**OUTLINE APPLICATION FOR DEMOLITION OF EXISTING BUILDING AND
ERECTION OF THREE STOREY BLOCK OF 17 ONE BEDROOM FLATS,
WITH ASSOCIATED CAR PARKING AND ACCESS FROM DURBAN
ROAD - AMENDED PLANS WESTSIDE SUPPLIES 17-18 DURBAN ROAD
BOGNOR REGIS**

**Proposed Development at Westside Supplies, 17-18 Durban Road, Bognor Regis
Flood Risk Assessment**

Scale	As shown	At original	A1
Drawing Number	1164/01	Revision	A

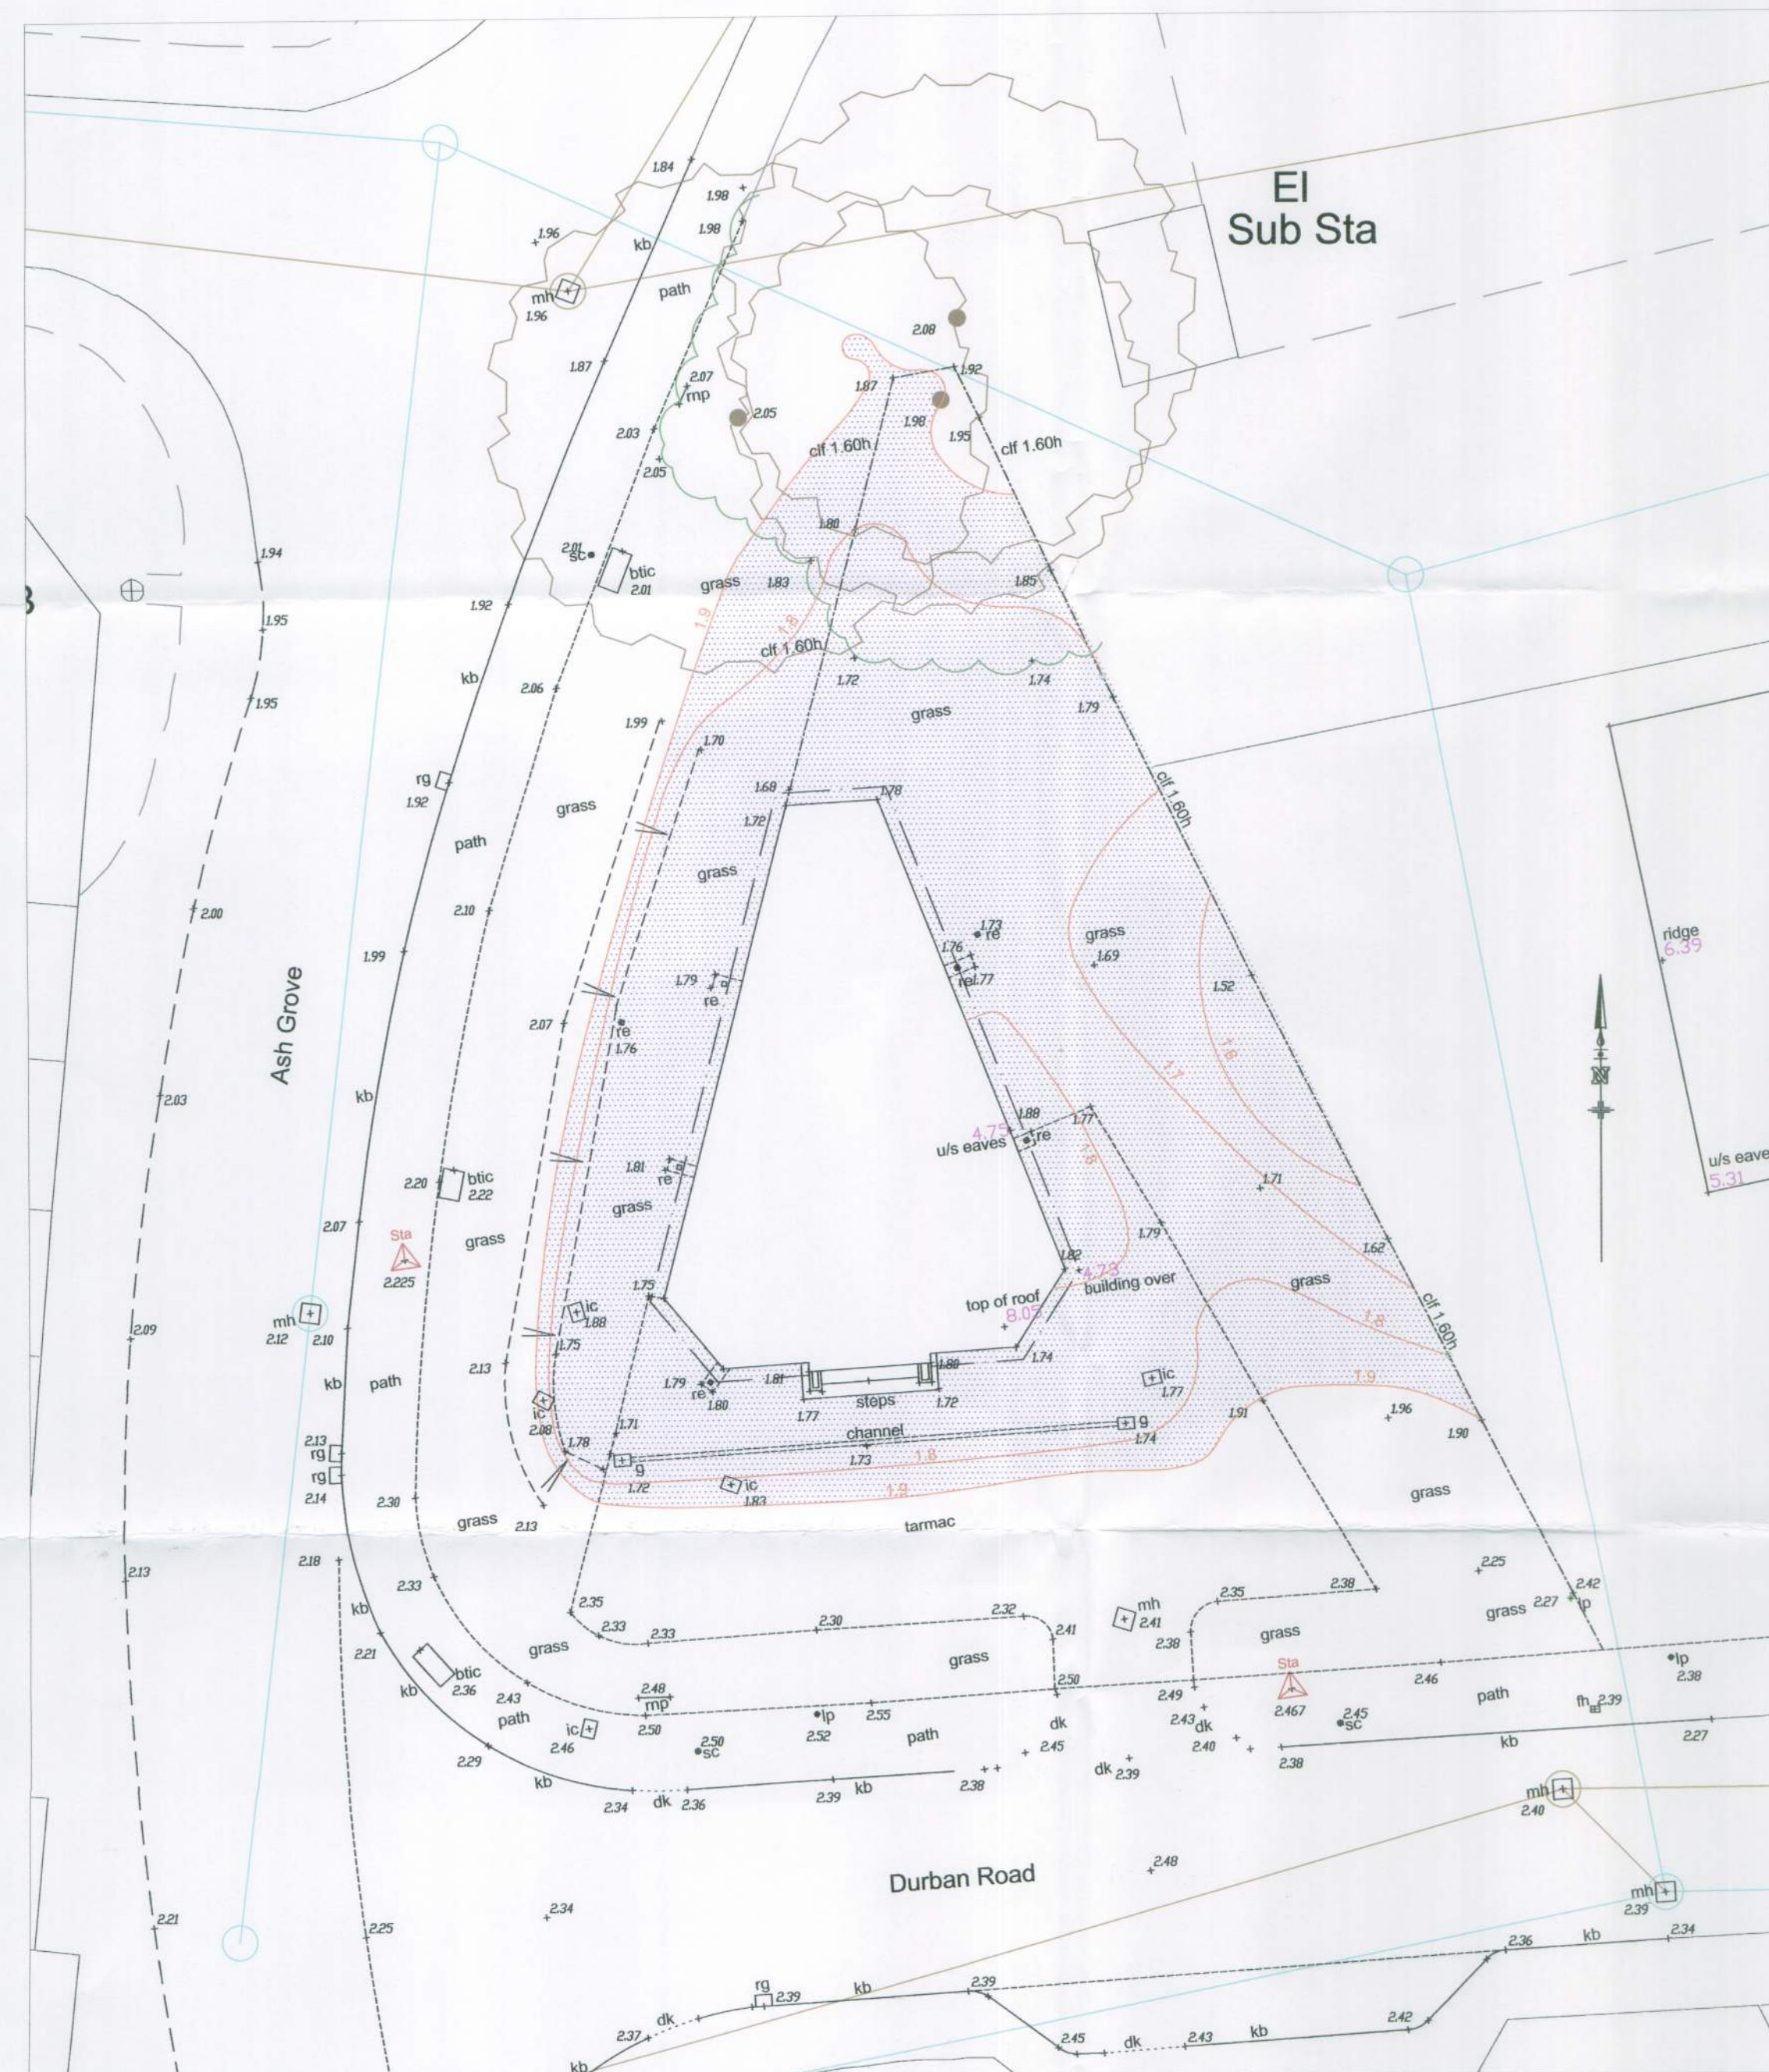
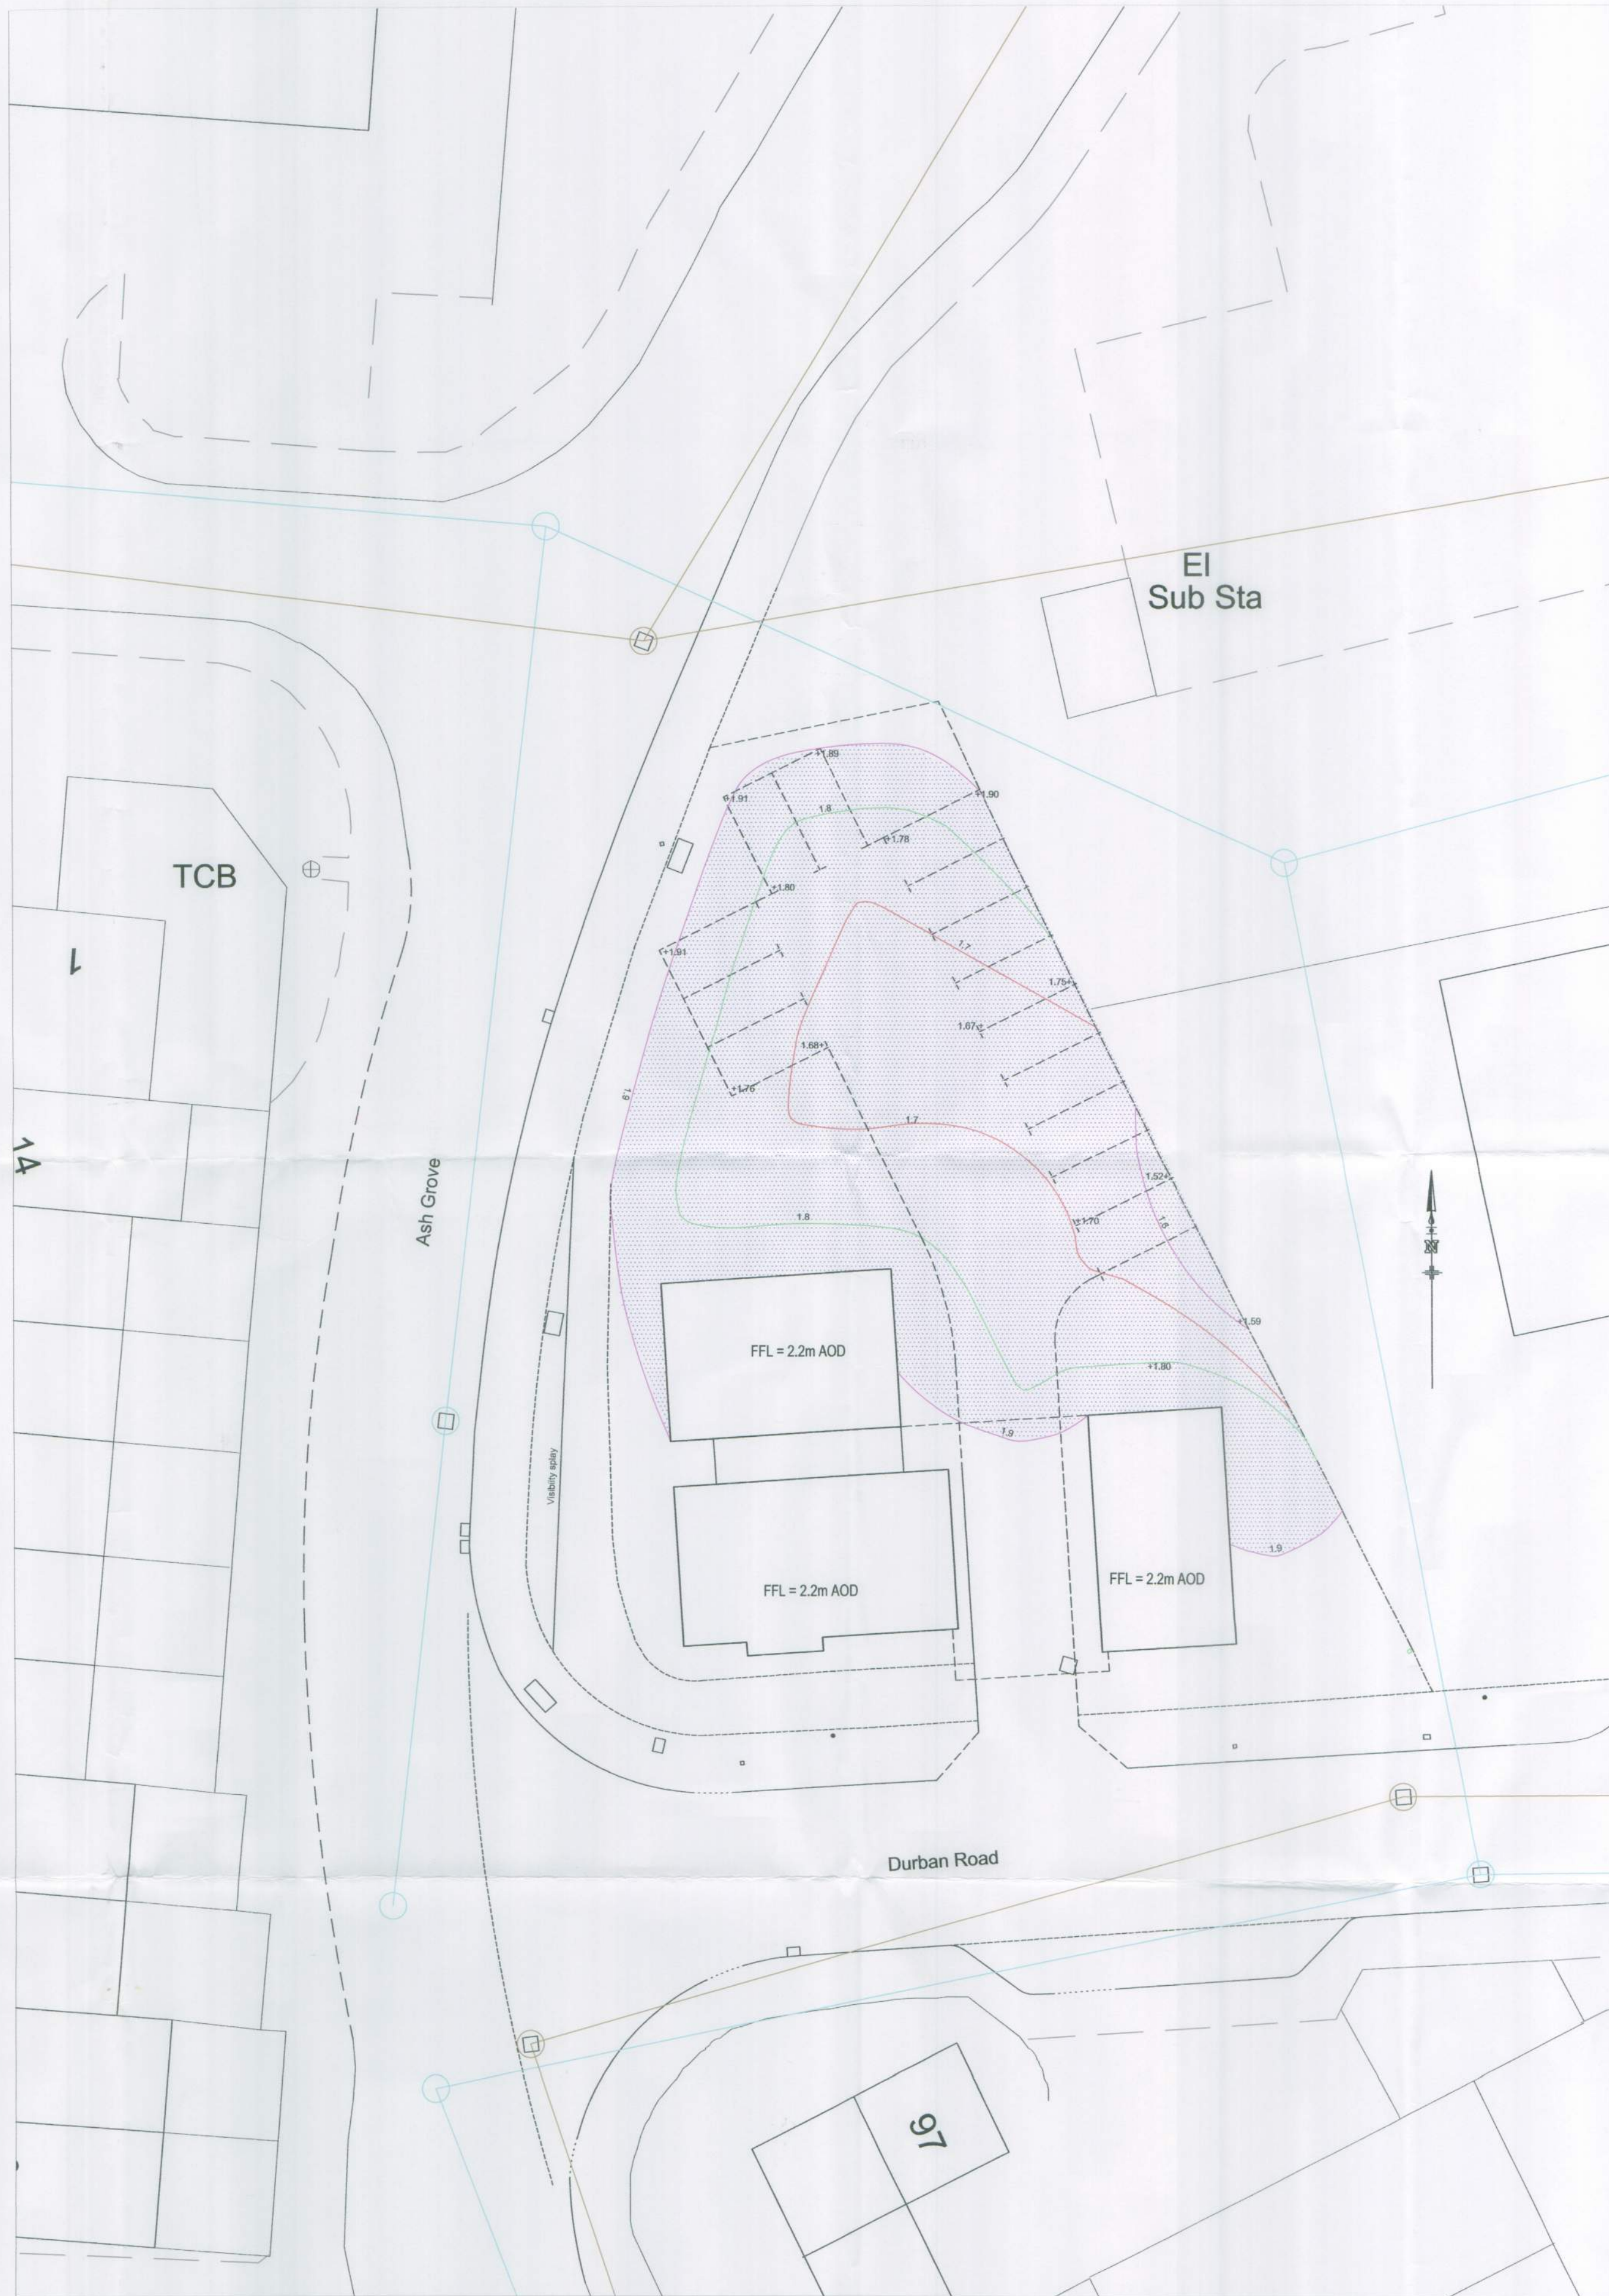
Please see the enclosed plan, Drawing No. 1164/1.1A, indicating revisions to the development layout and slight amendments to the proposed site levels/ contours.

The volume of new flood storage is now around 82.1 m³ compared with the previous storage of 80.2 m³ and existing storage of 79.7m³.

Thank you for forwarding your revised layout and amendments as indicated in
Drawing No. 1164/01 Revision A.

I can confirm that we are satisfied with your submitted Flood Risk
Assessment.
